# ENG-CDR19004-R1-CDR-Redlines Summary\_Markup Summary

MERIDIAN ROAD DRAINAGE PLAN

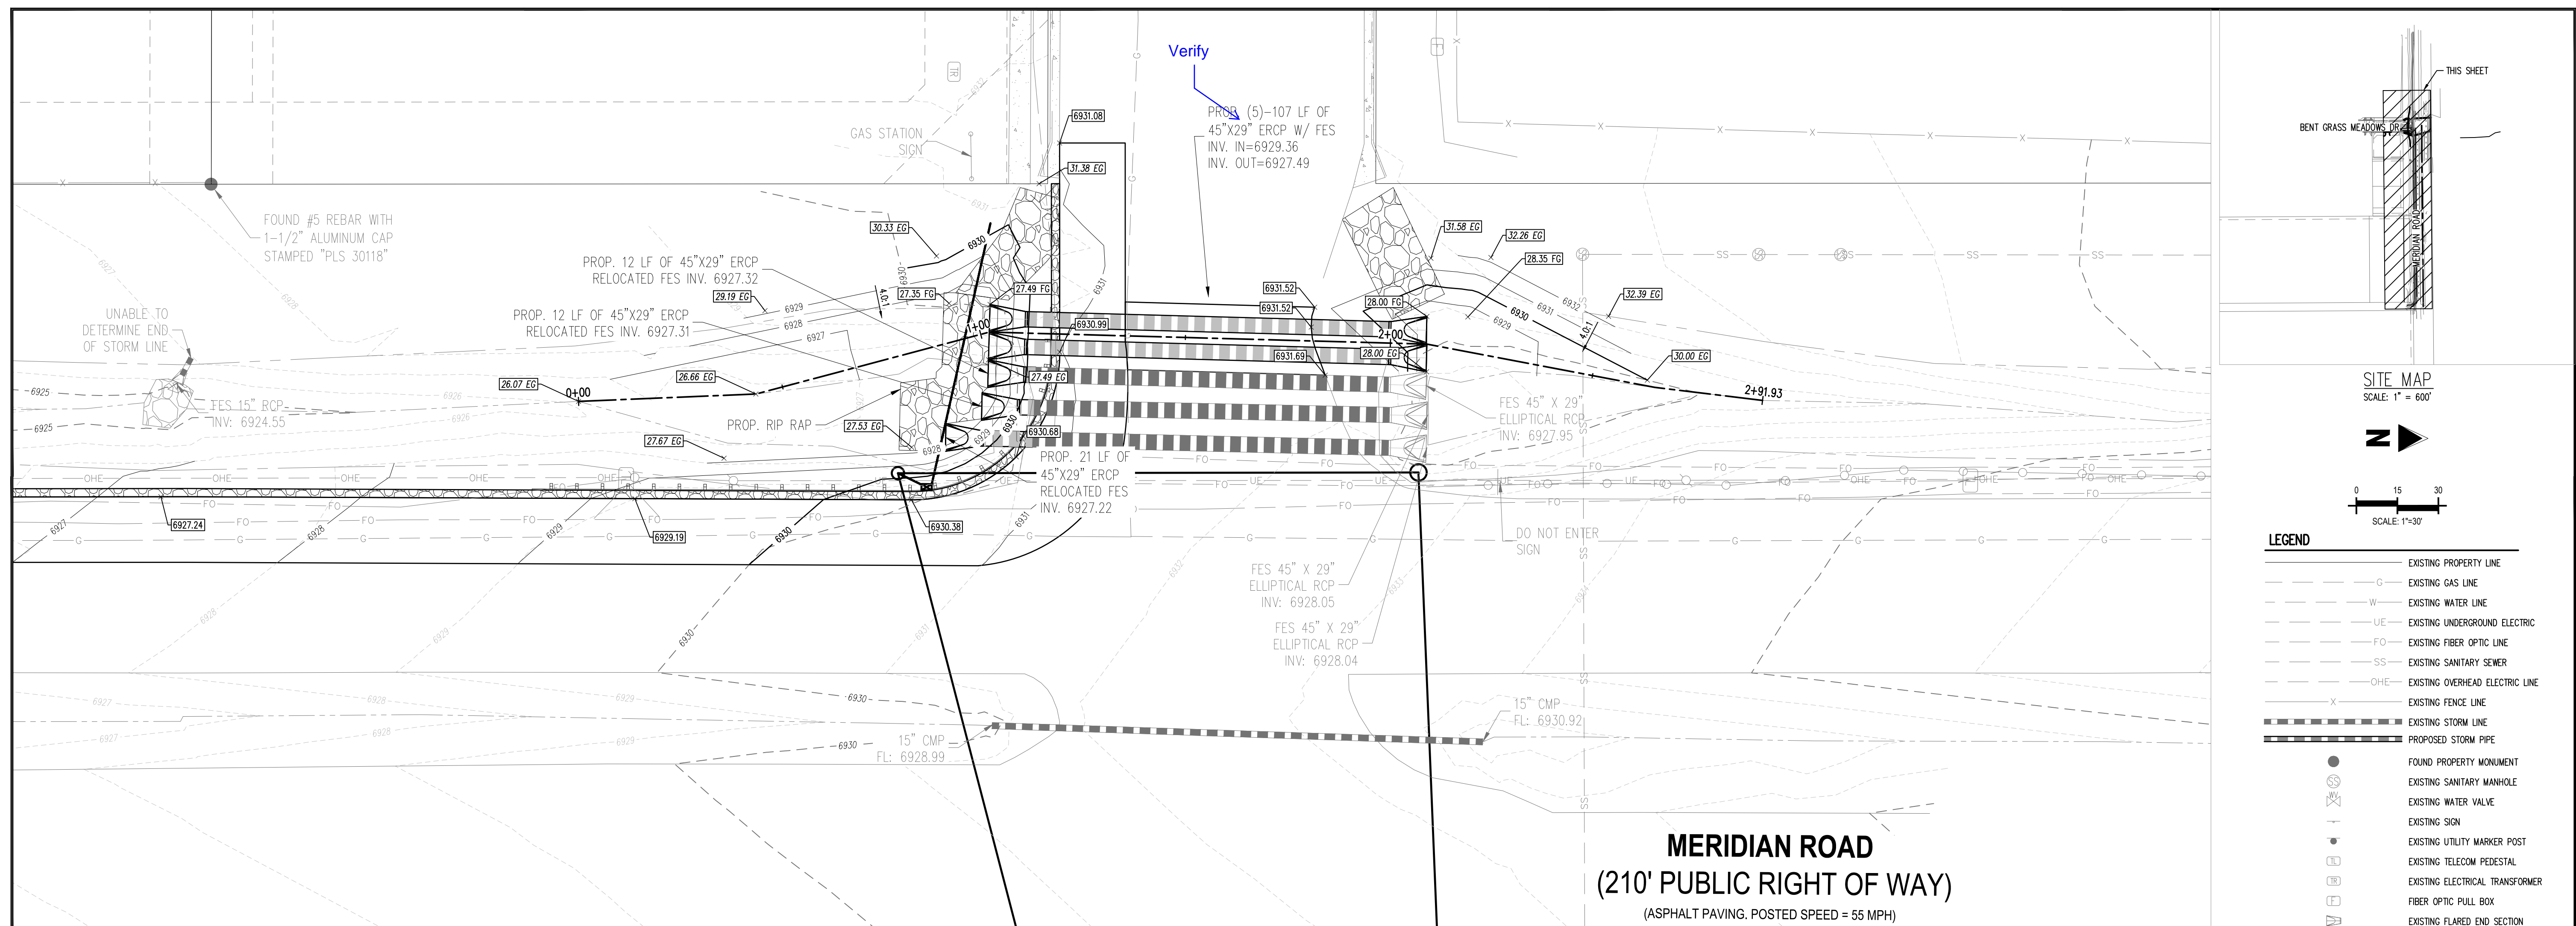
Address existing downstream detention/WQ.

Address current channel condition and stability.

Describe downstream detention. See comment letter.
